Cover letter to **Objection** submission

SSD-6696-Mod-1

Objection to MOD - : Liverpool Range Wind Farm

Figure 4.1 Realistic case scenario shadow flicker duration map, Modified Project, (maximum of 2 & 6 mAGL)

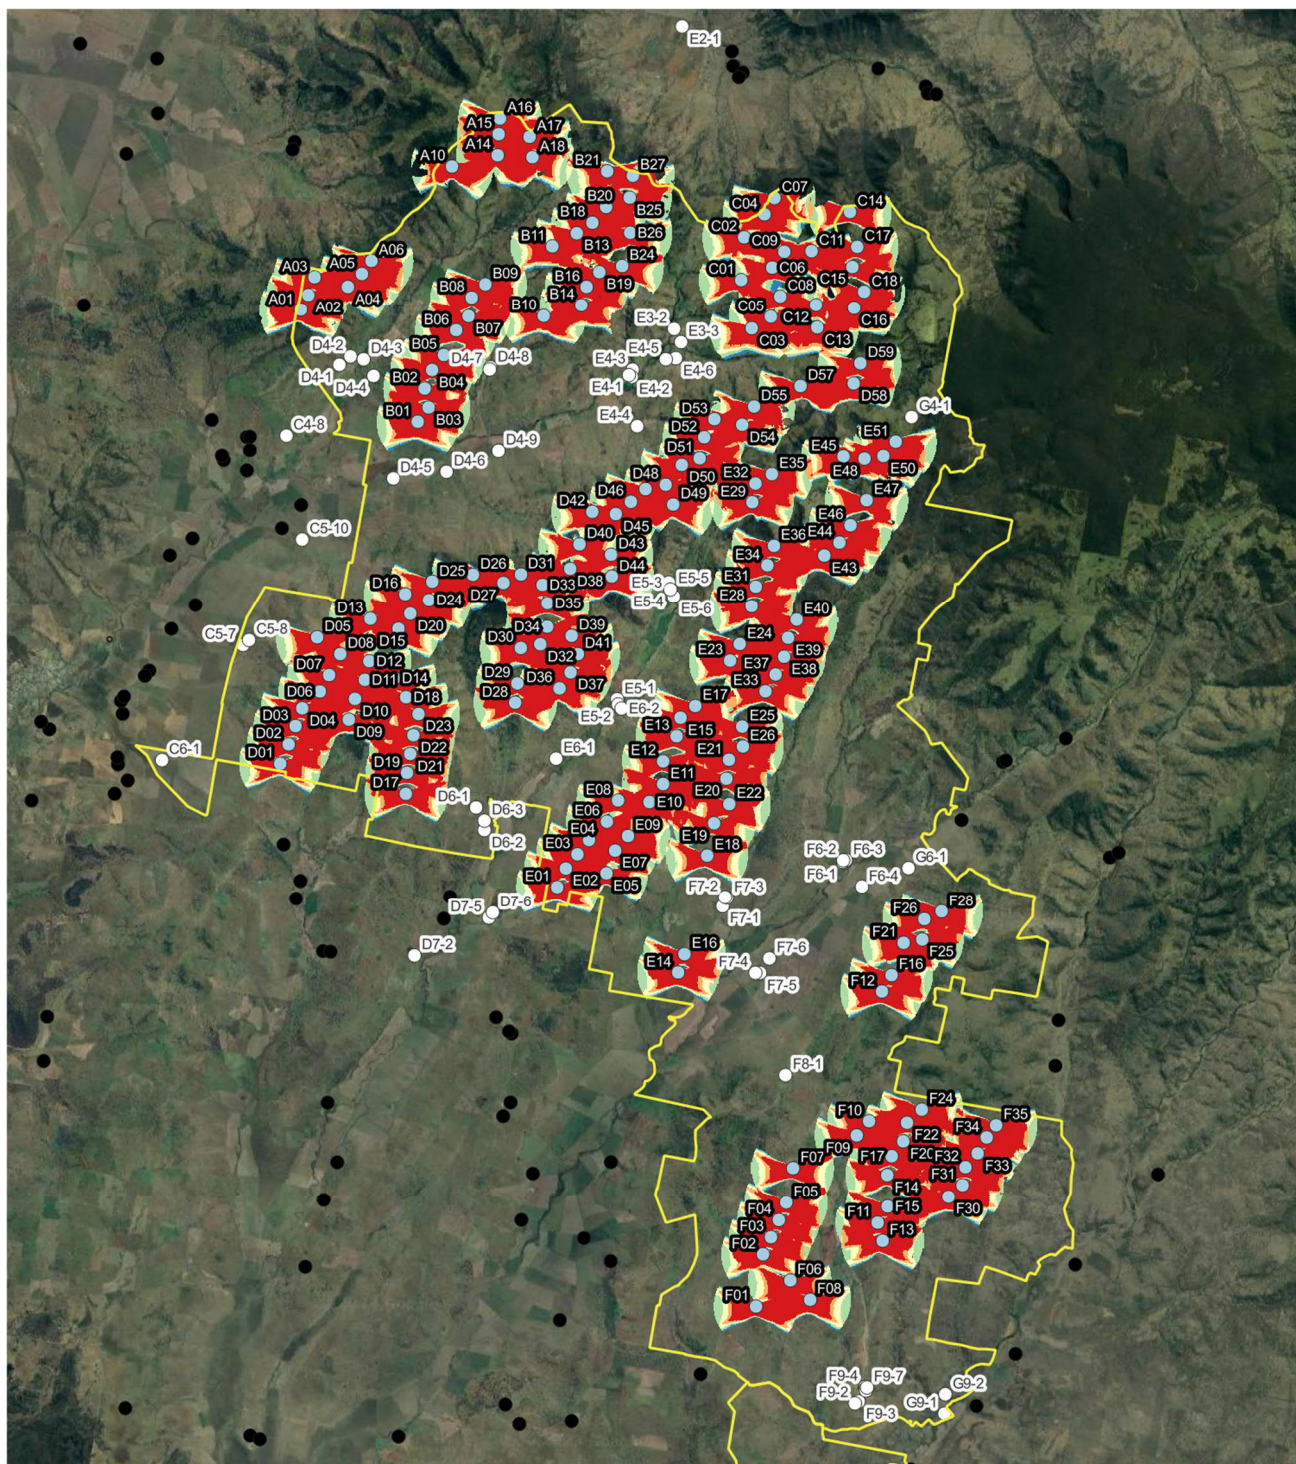
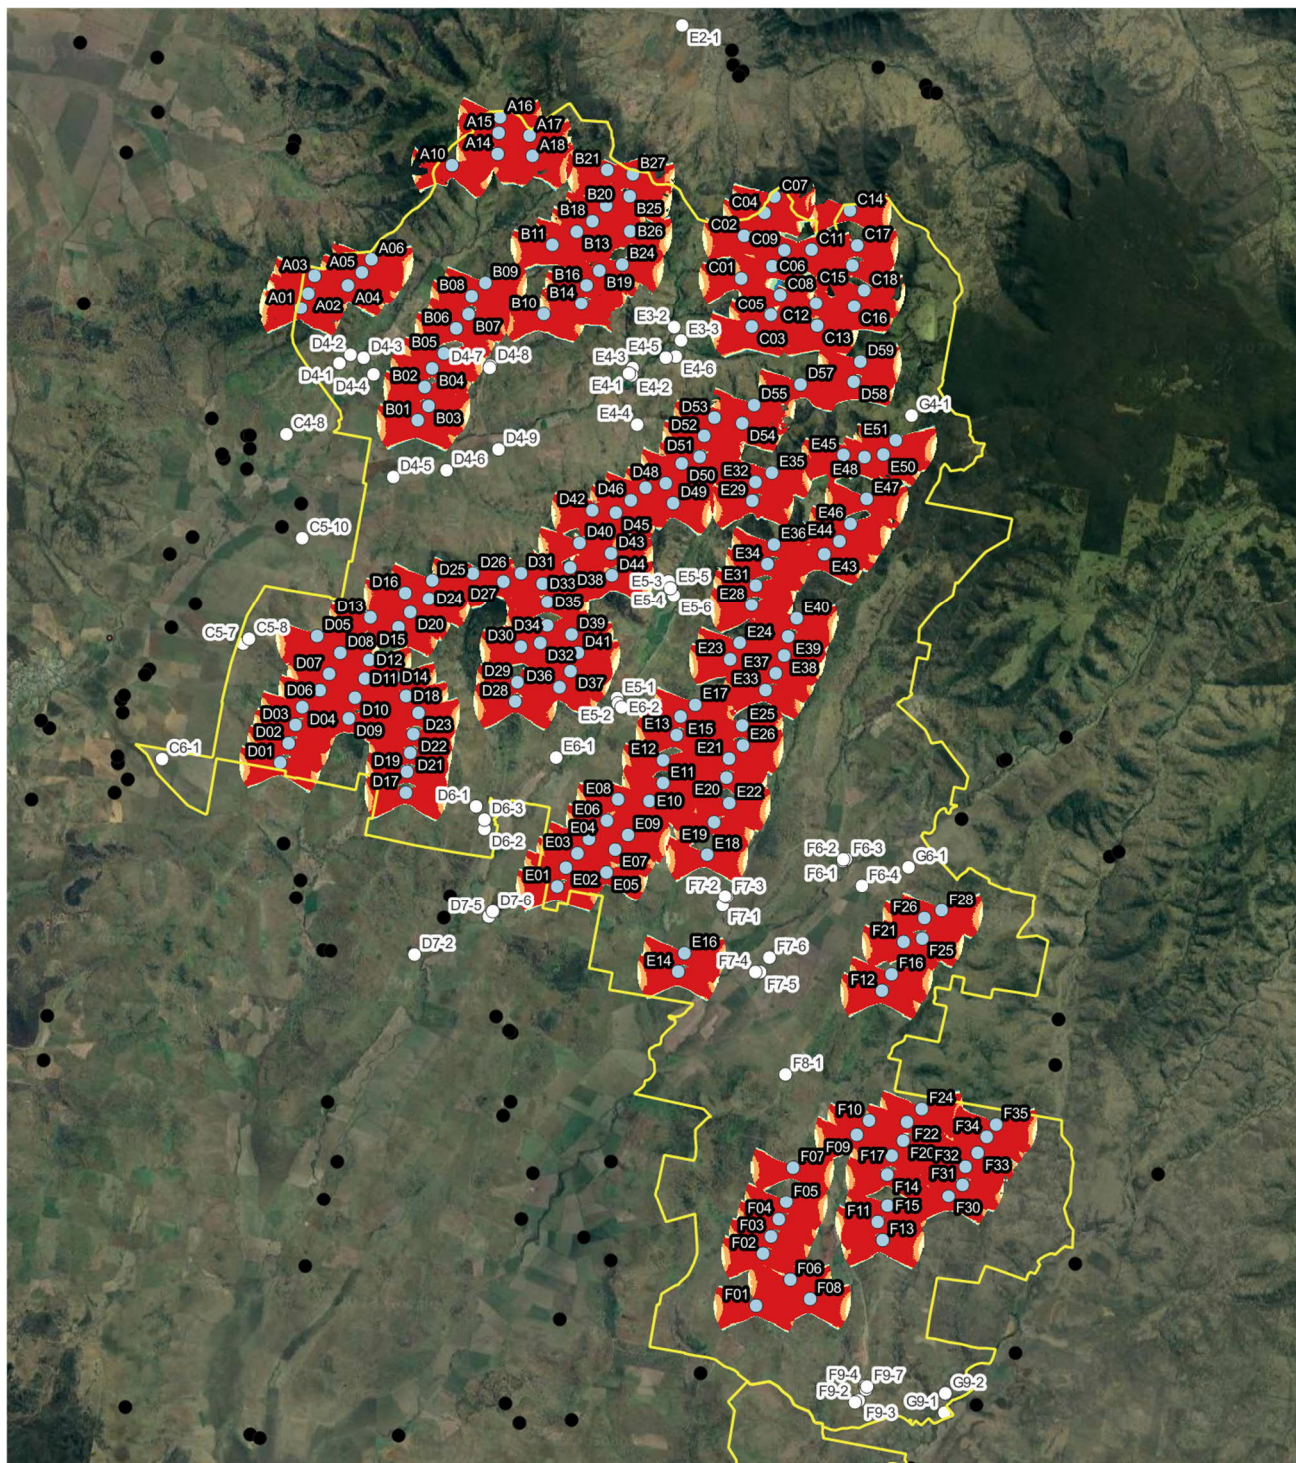
G2 shadow flicker 3:1 and 3:3 table 3:2. Appear to only allow for summer sun and not the low lying winter sun conditions.

- increased non-associated dwellings experiencing shadow flicker
- increased traffic of around 300+ vehicle movements per day (one way), so 600+ on local roads over the approx. 3 year construction period.

Liverpool Range Wind Farm
Indicative Over-size/over-mass (OSOM) Haulage Route - Port of Newcastle to Project Site

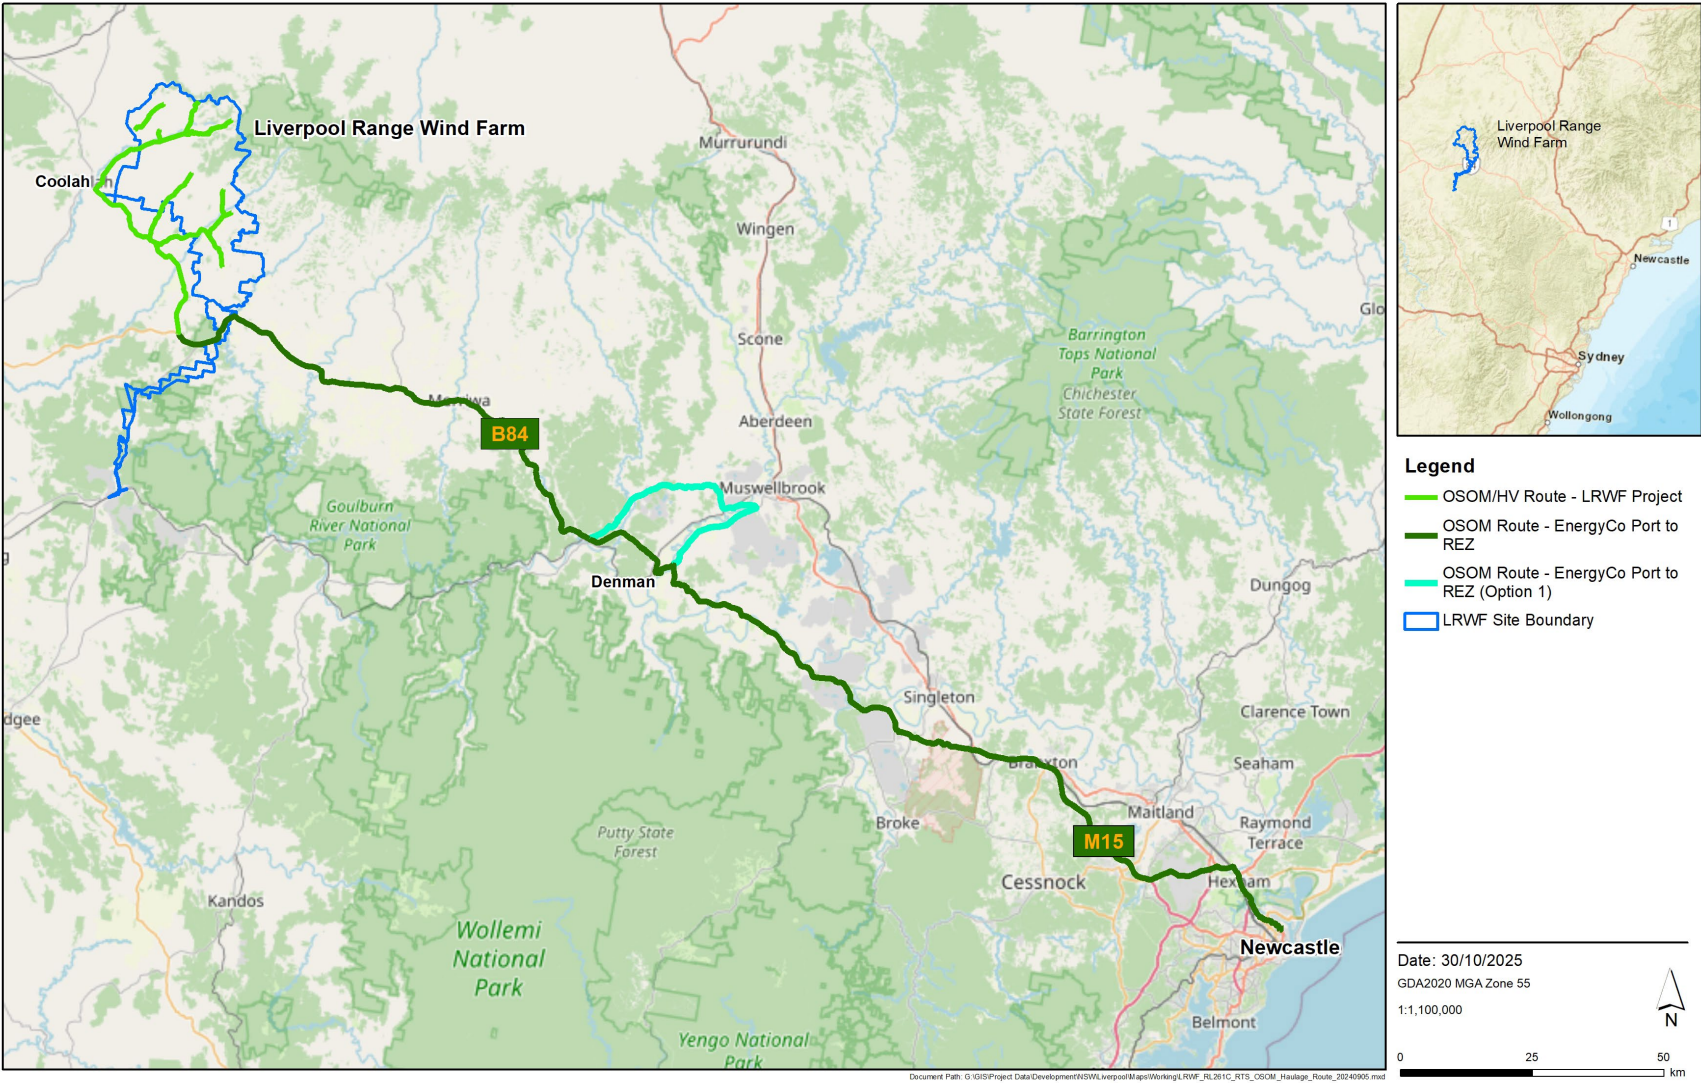
5.1 there appears to have non connected routes for OSOM (Gundare Road Coolah) which indicates that there would have to considerable development through private property possible (Mount Mill) to cross our Coolaburrgundy River to access this area.
